**Wentworthville Northside West Clinic Extension (SSD-17899480)
Response to Submissions**

ATTACHMENT 1 – KEY ISSUES / FURTHER INFORMATION REQUIRED

03 Strategy | Ground Level Details Plan - Lytton Street Streetscape

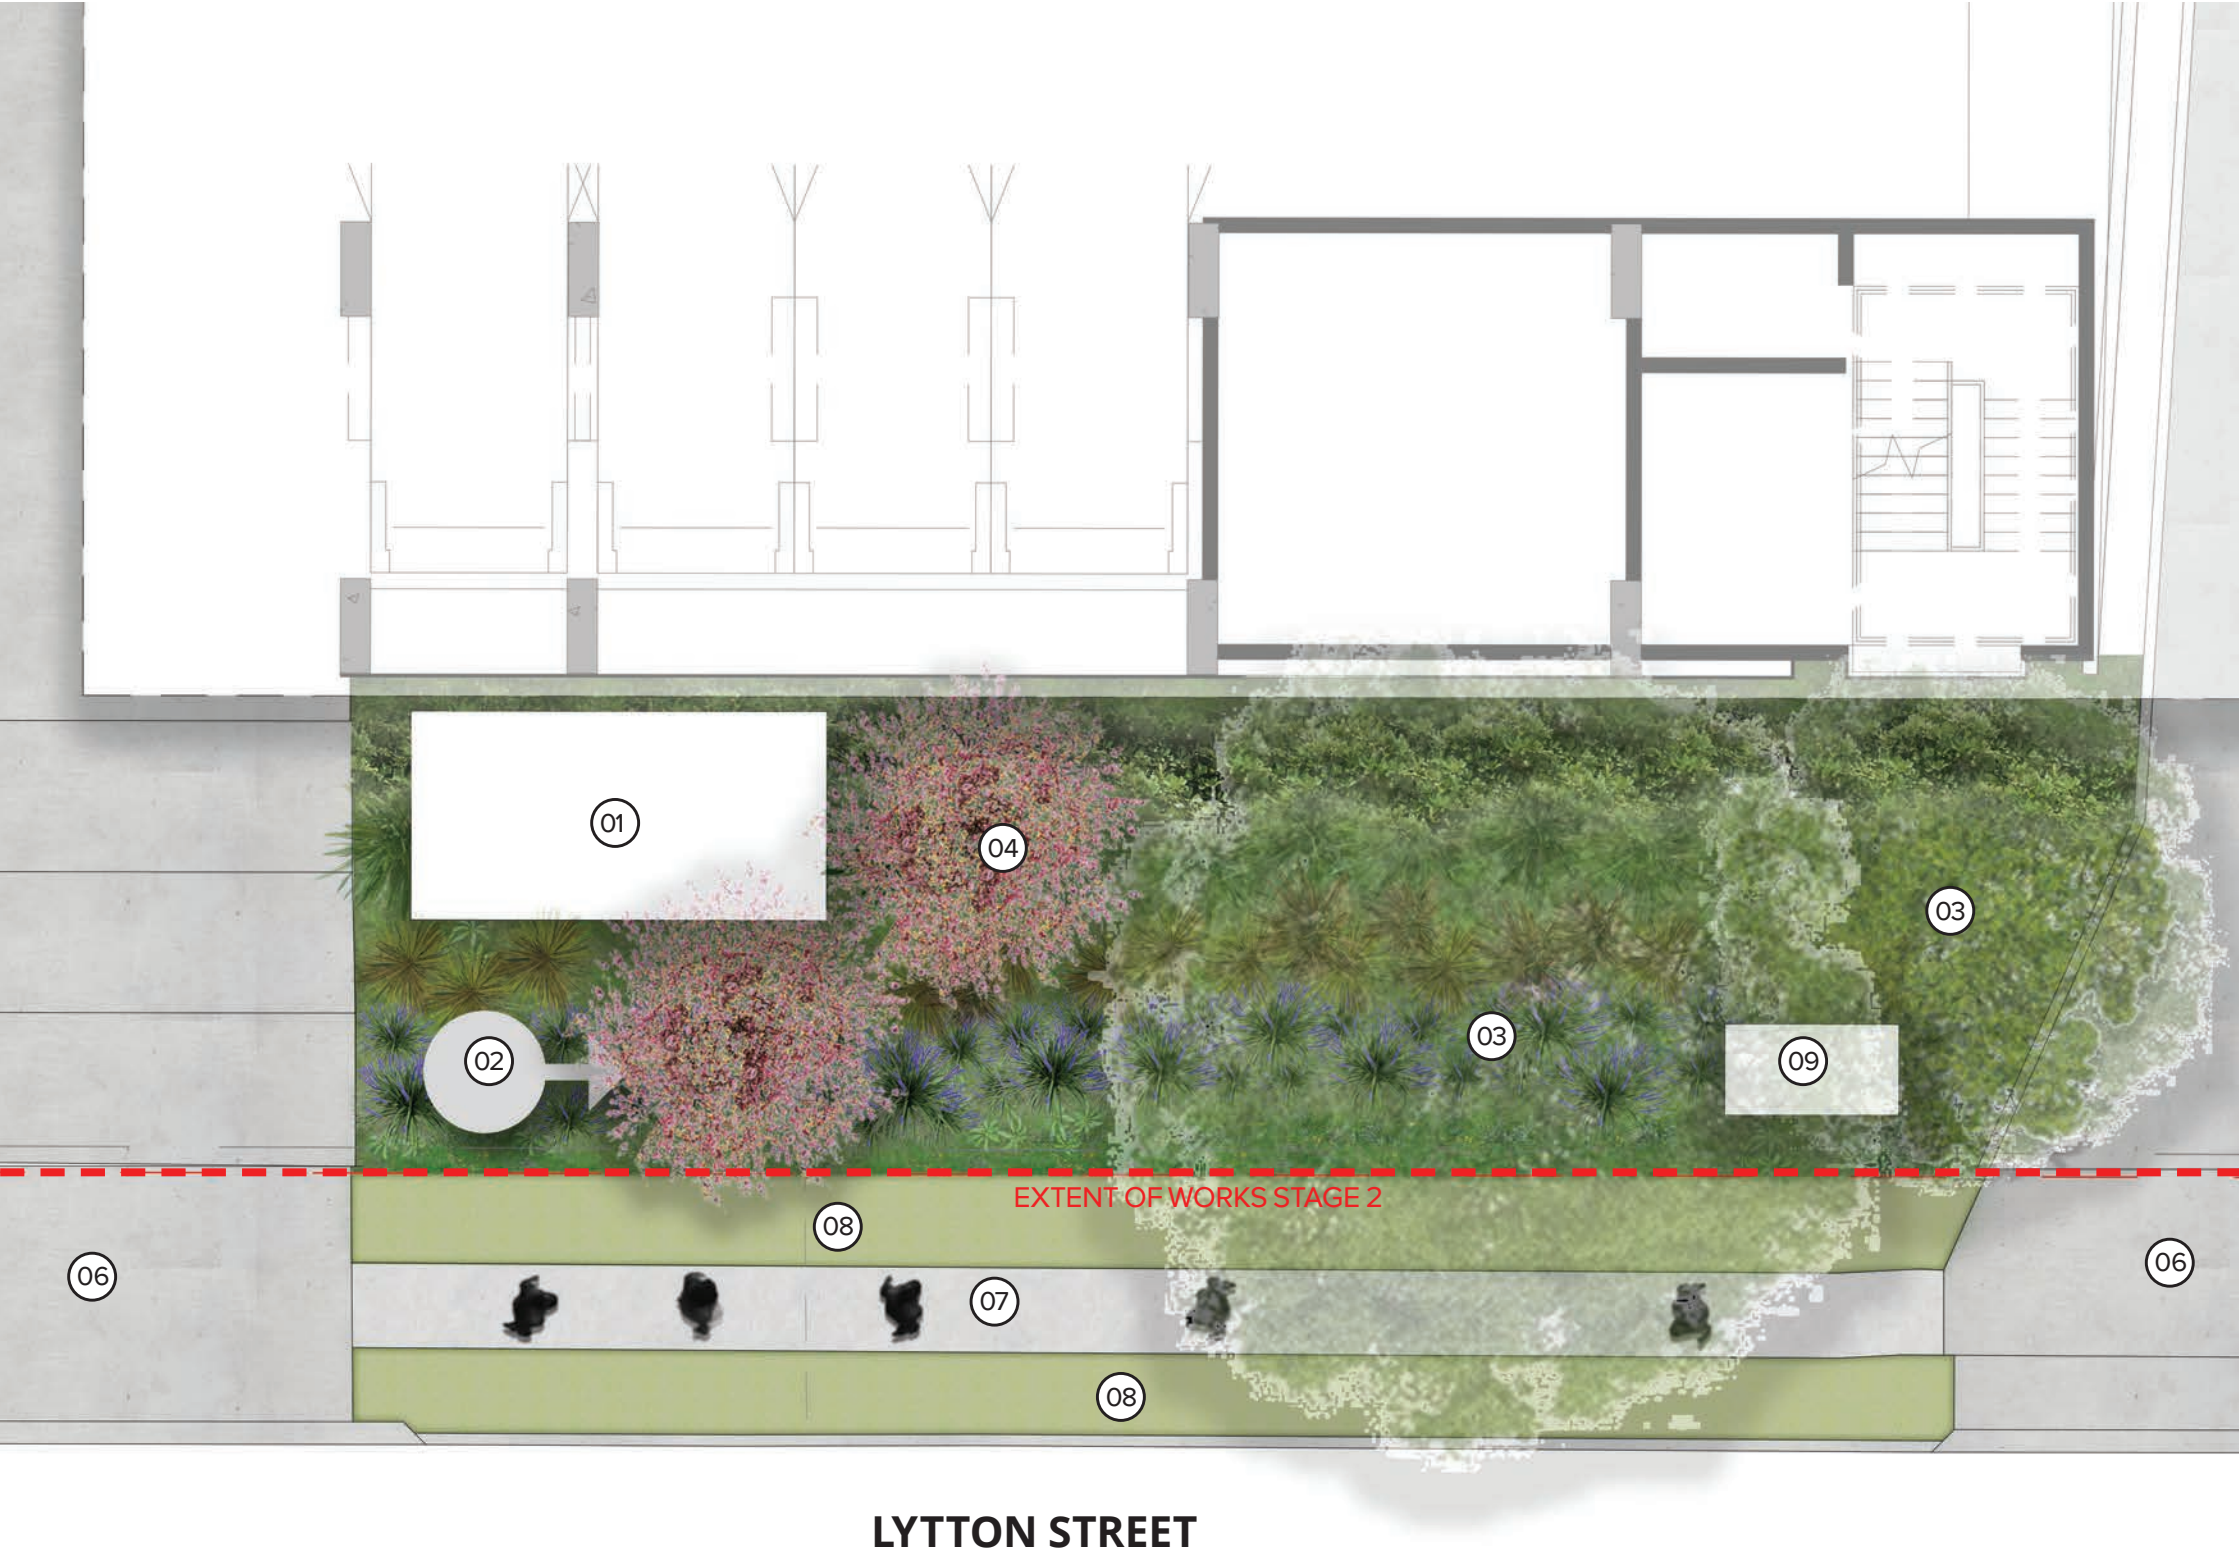
16. Include details of landscaping along Lytton Street providing improved amenity for the public ensuring visibility and appropriate sightlines are maintained as well as improved landscaping to soften the streetscape and utility rooms on ground floor.

03 Strategy | Level 2 Courtyard

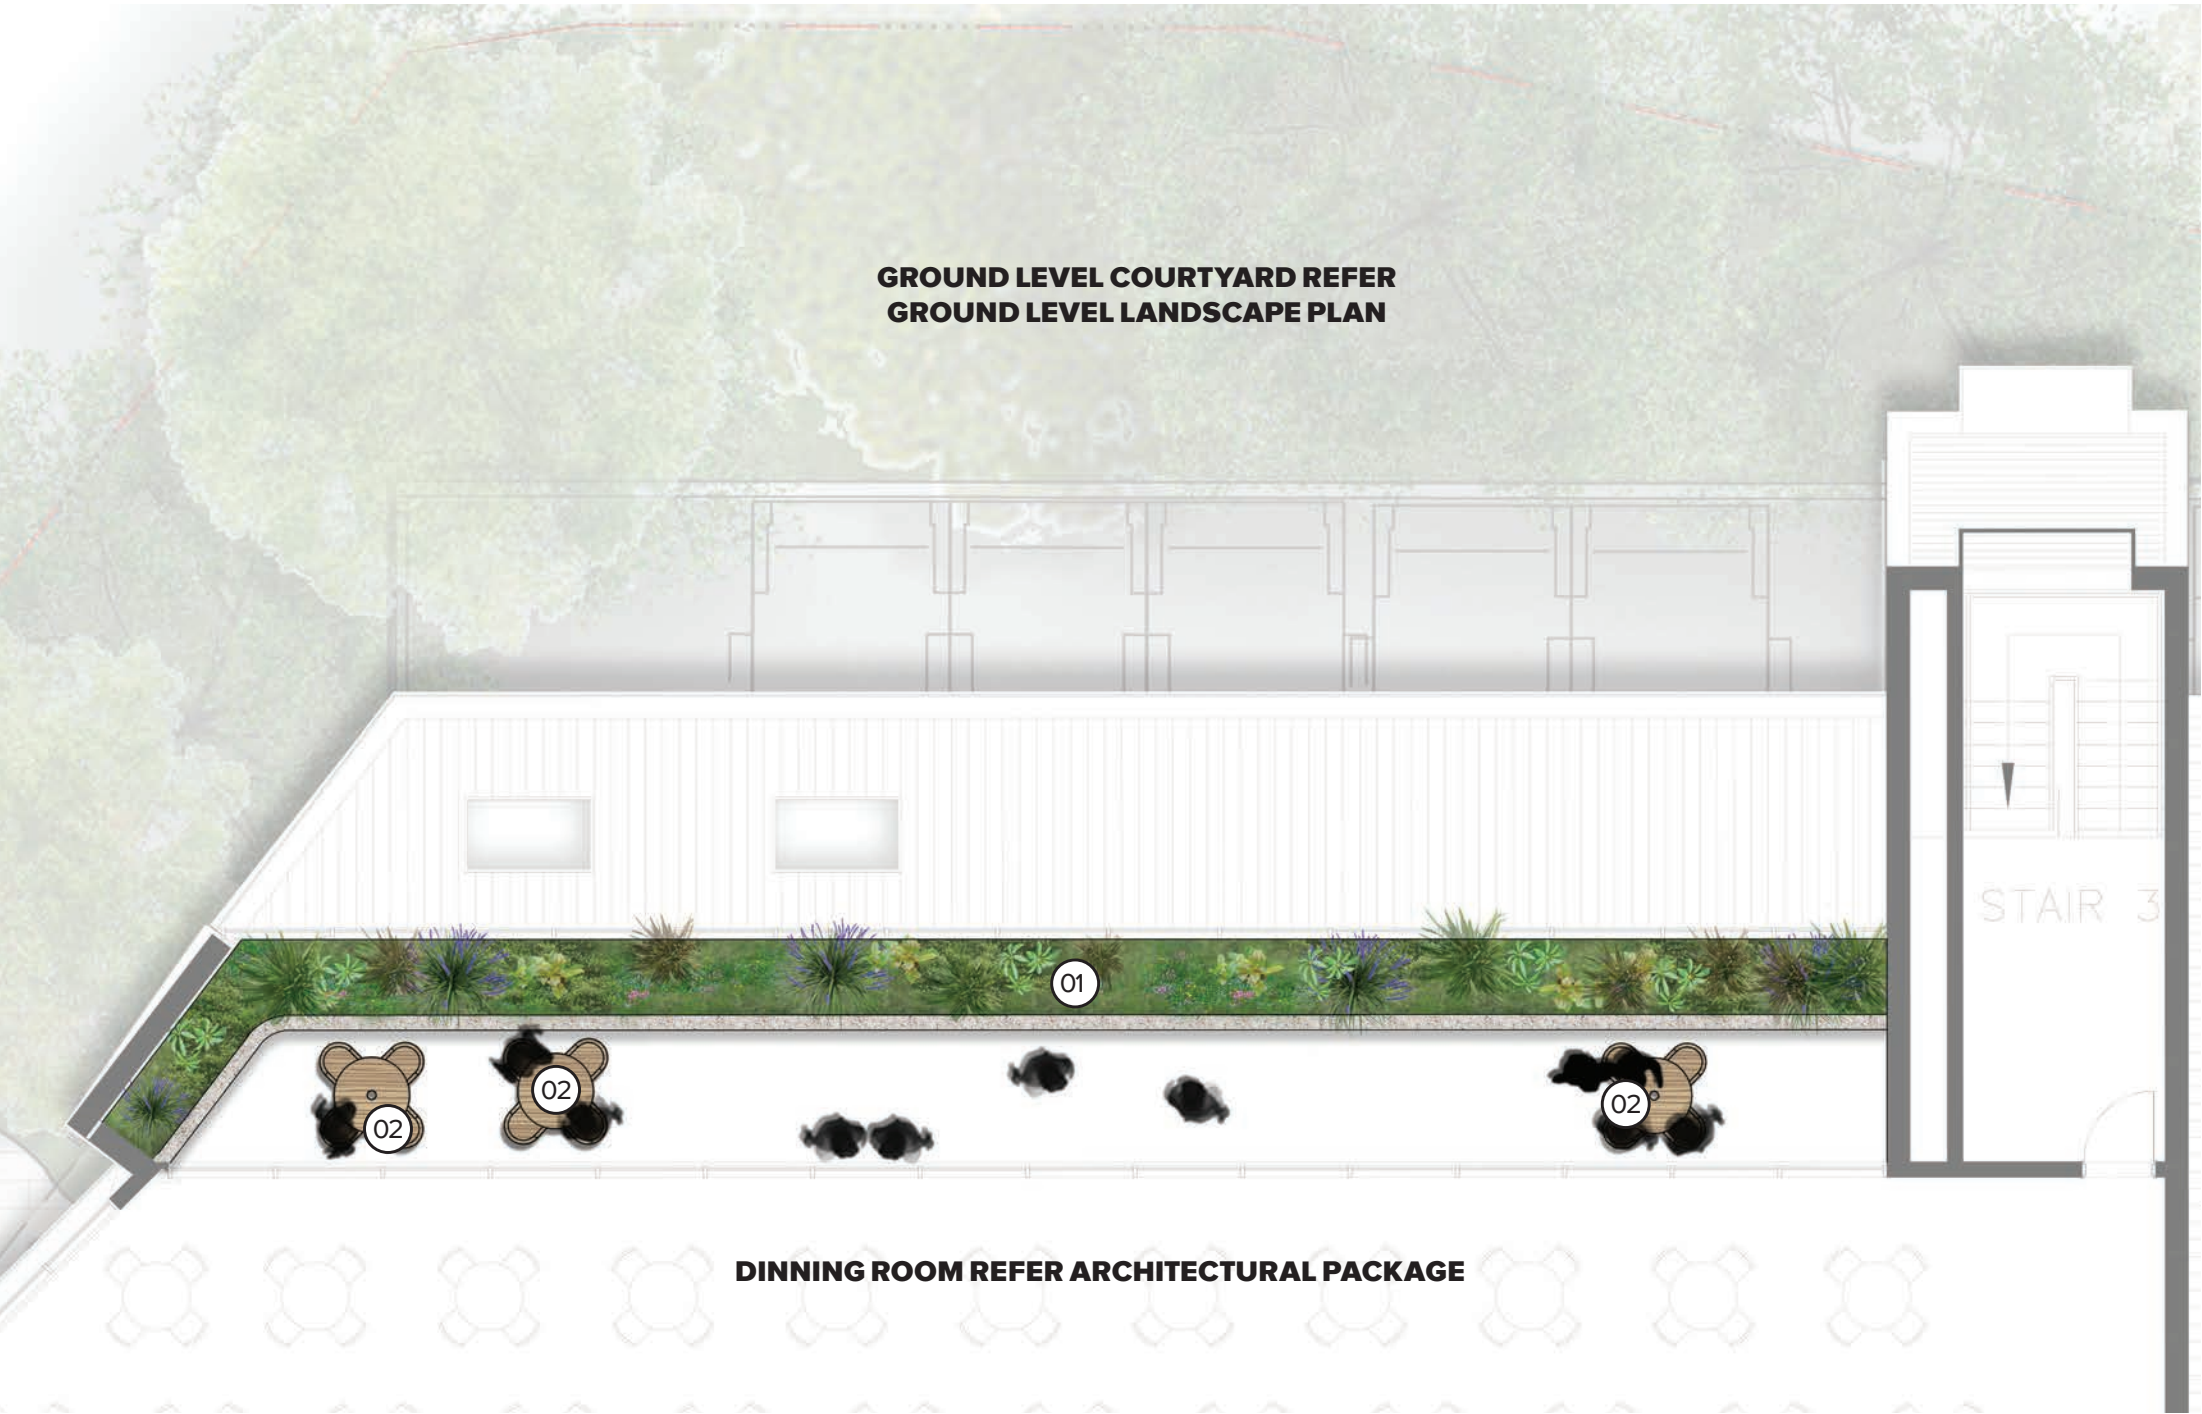
- provide detail of all landscaped areas, particularly the terraces across all floors of the development (Levels 2 and 3 in particular), demonstrating areas for passive activities and improved amenity.
- redesign courtyard 1 to ensure a more permanent and integrated landscaped space.
- identify the total percentage of tree canopy and green space within the site excluding trees located outside of the subject site on surrounding properties.
- provide detail within the landscape strategy and architectural plans of the green walls and herb gardens as detailed within the Architectural Design Statement.

1 DA - Lower Ground West Parking and Stage 1
Scale: 1 : 100

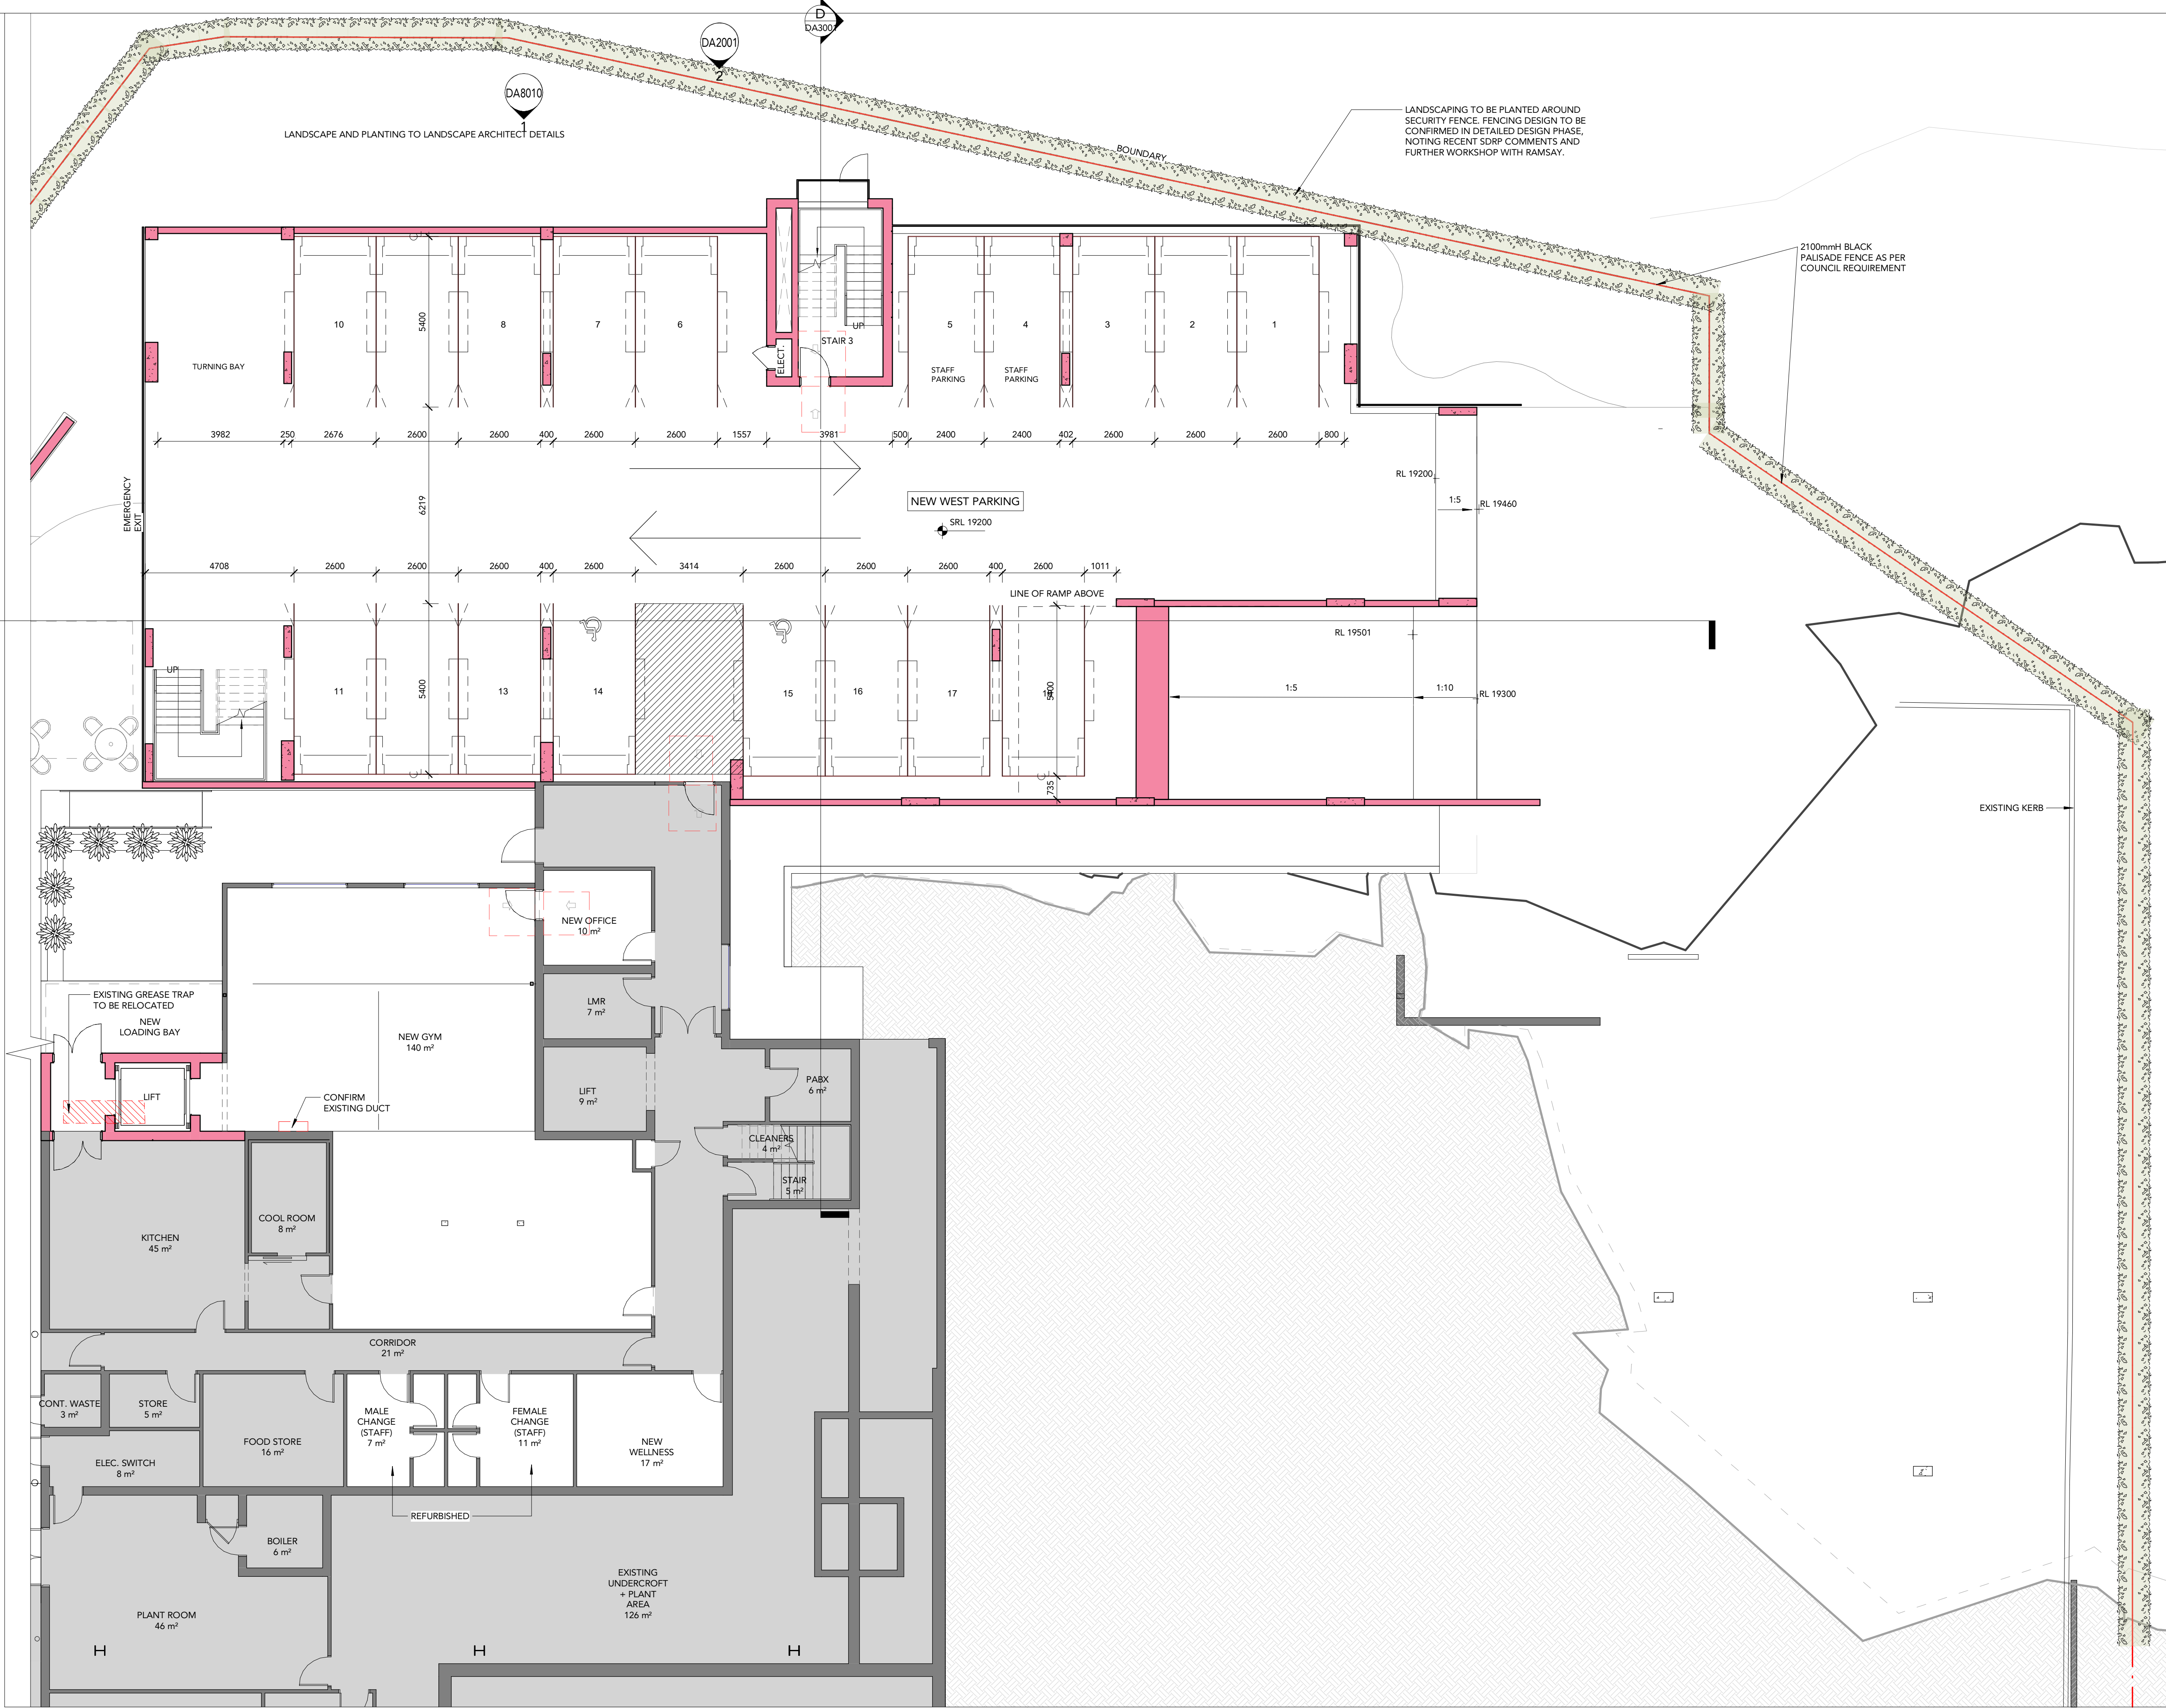
9. Redesign the lower ground car parking to ensure that the swept paths are free from obstructions.
